Addendum No. 1

RE: Contract # C204169

Randolph County

3 Sections of US-421, 6 Sections of US-220 Business

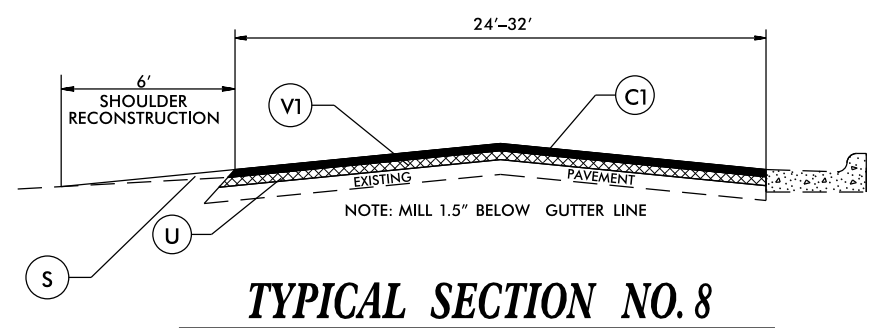
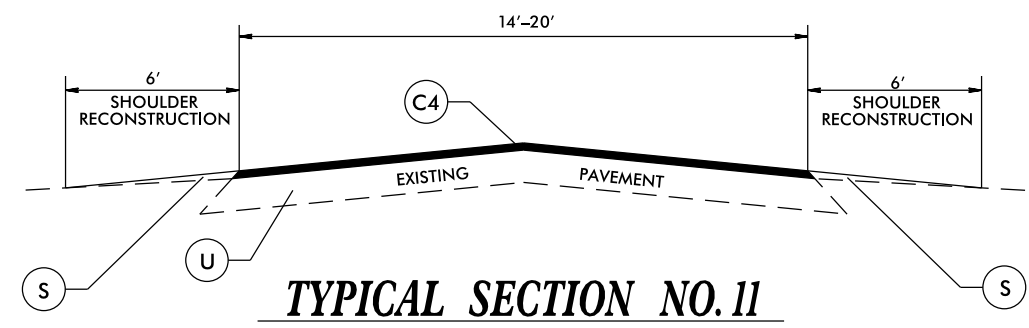
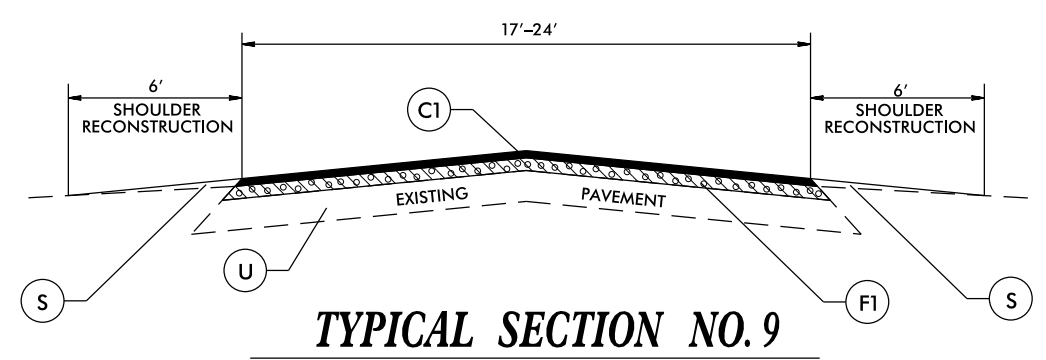
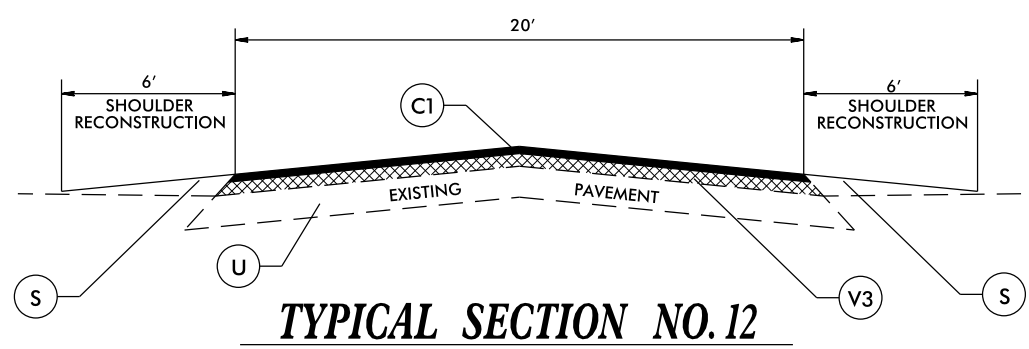
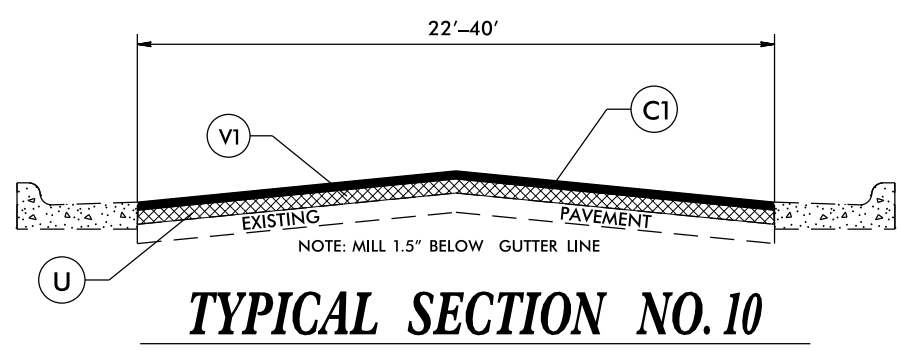
Sheet No.	Revisions
7	Revised to add Maps # 58, # 59 and # 60
New 12A	New Sheet added to show typical sections for new maps # 58, # 59 and # 60
16, 17, 18 and 19	Revised to show quantities and new pay item due to adding the 3 new maps
